Summary of contribution to CAH1.

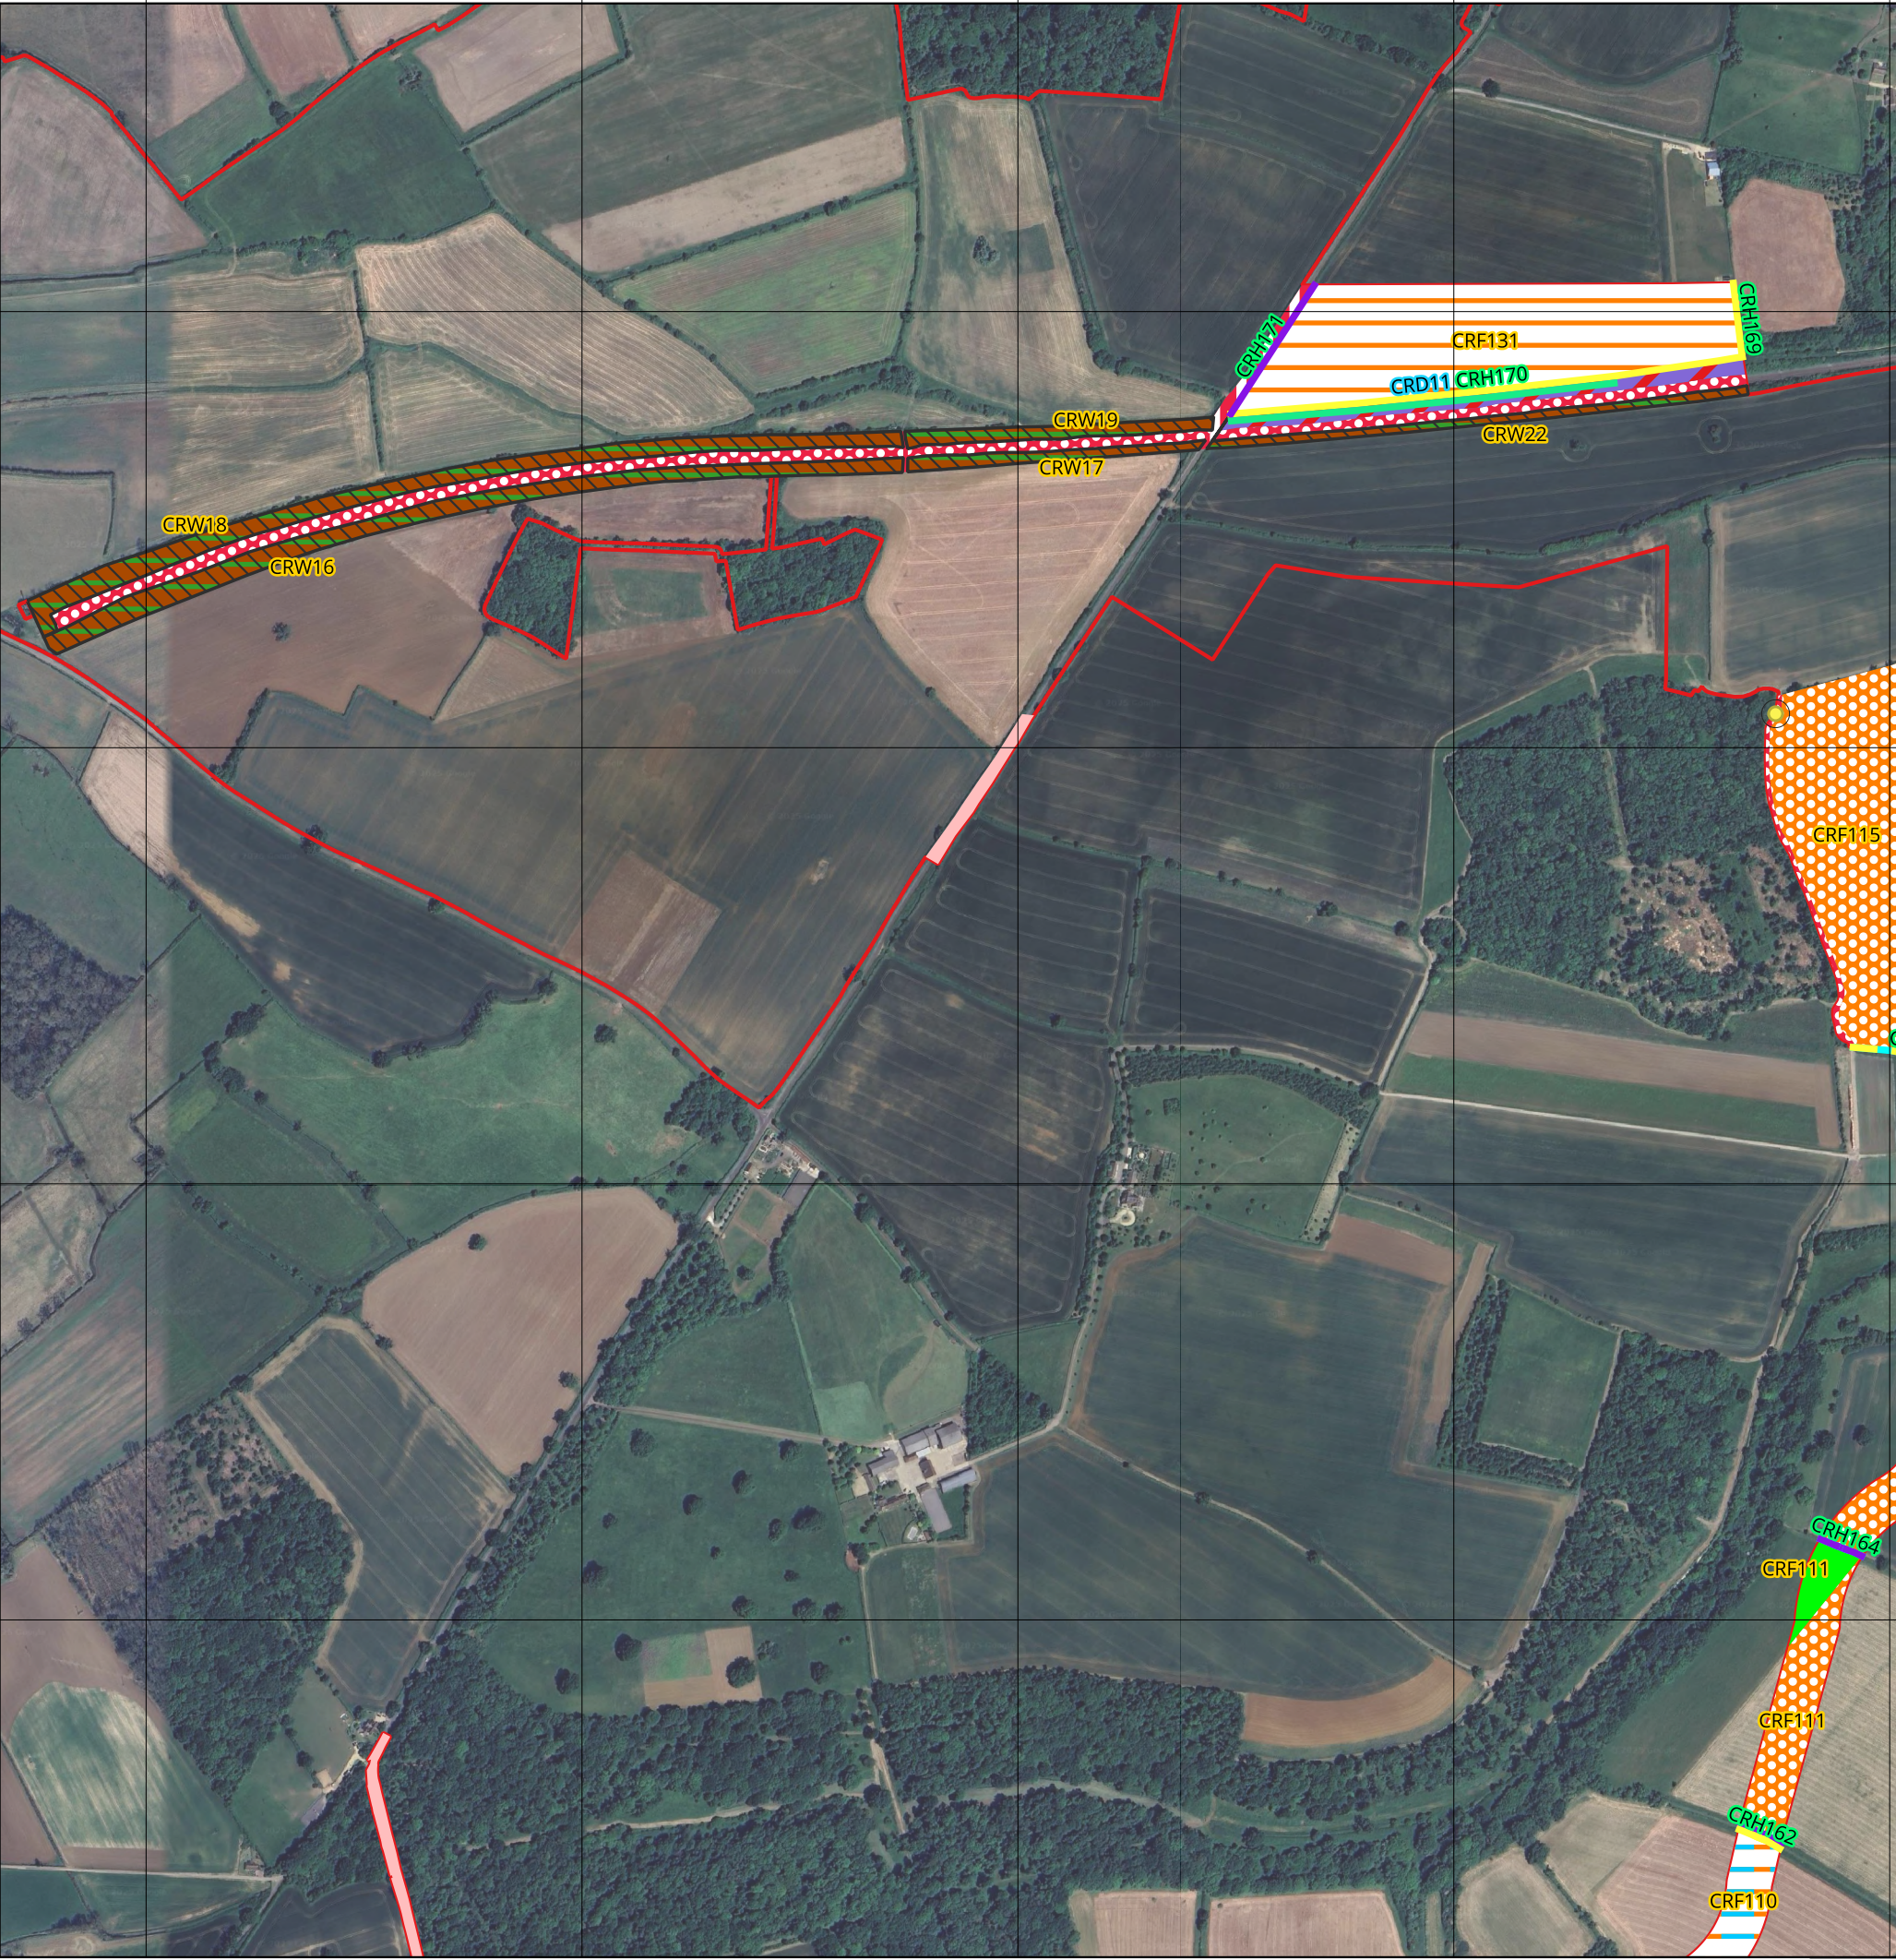
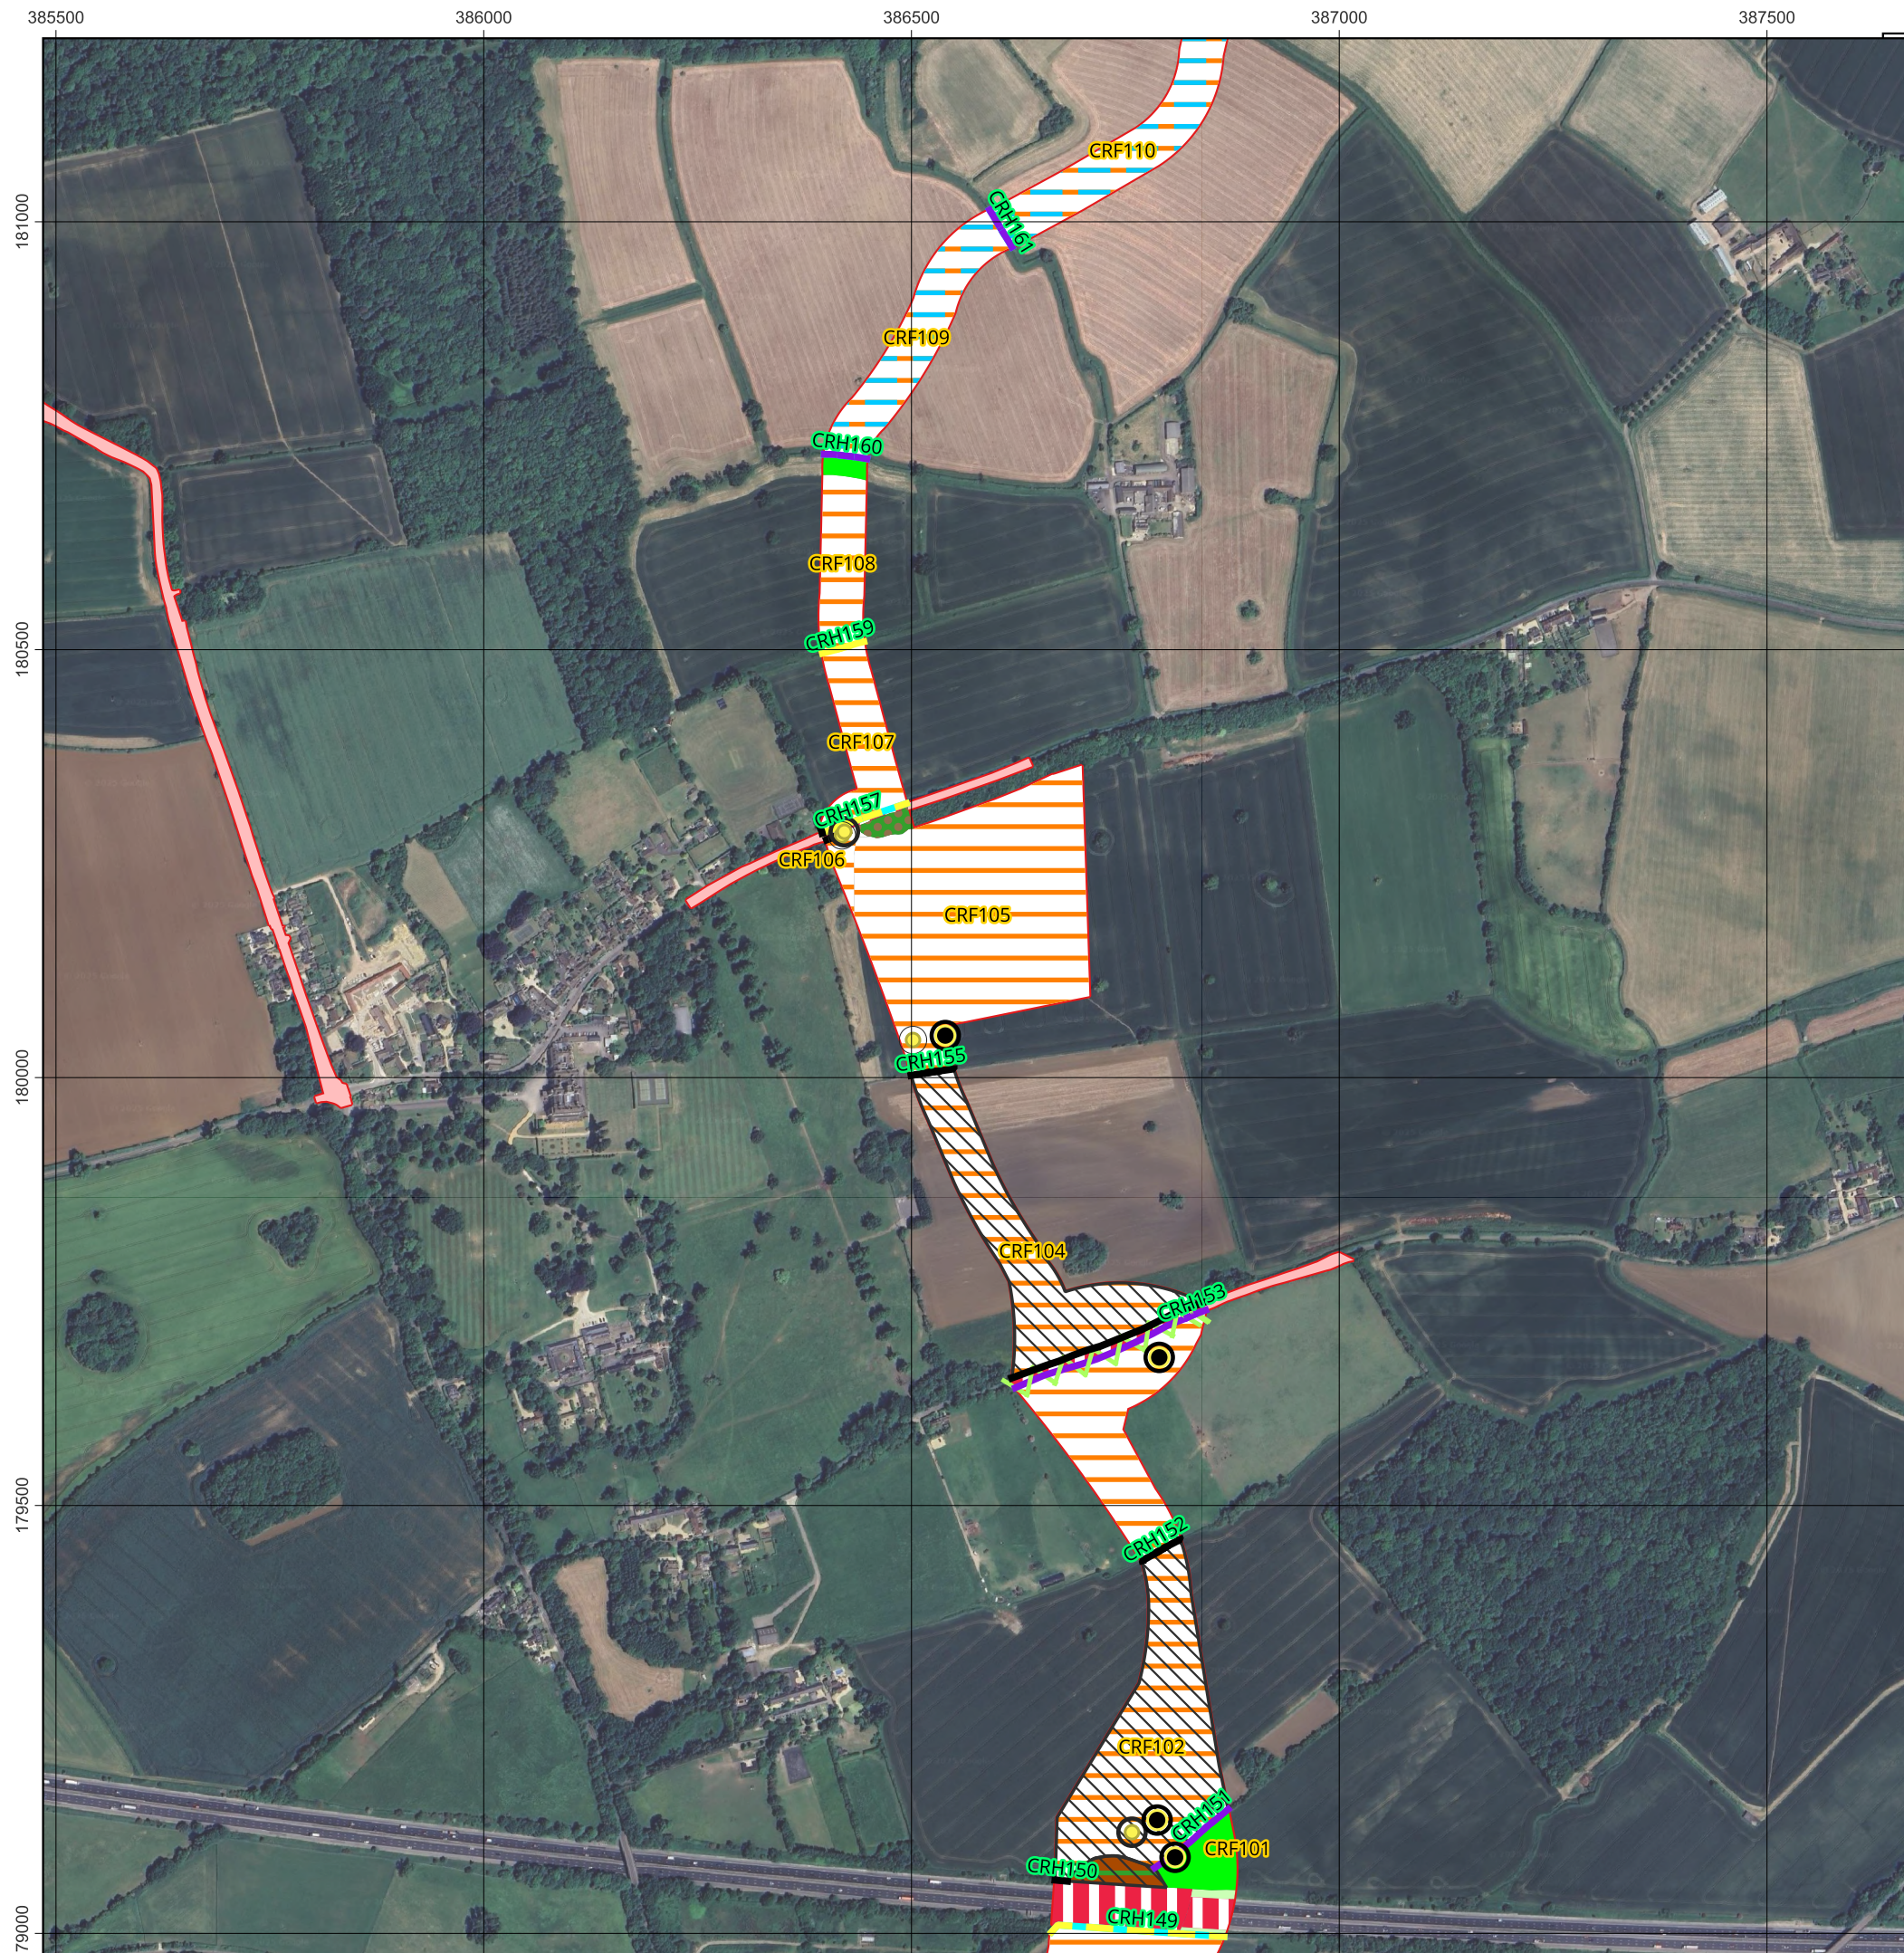
A further observation revolves around the Baseline habitat map and the designation of non-cereal crop and cereal crop. I'm wondering if there is any meaning to these criteria? Clearly the designation was recorded at the time of the survey but it is now incorrect, due to crop rotation. Are there conclusions drawn from this data?
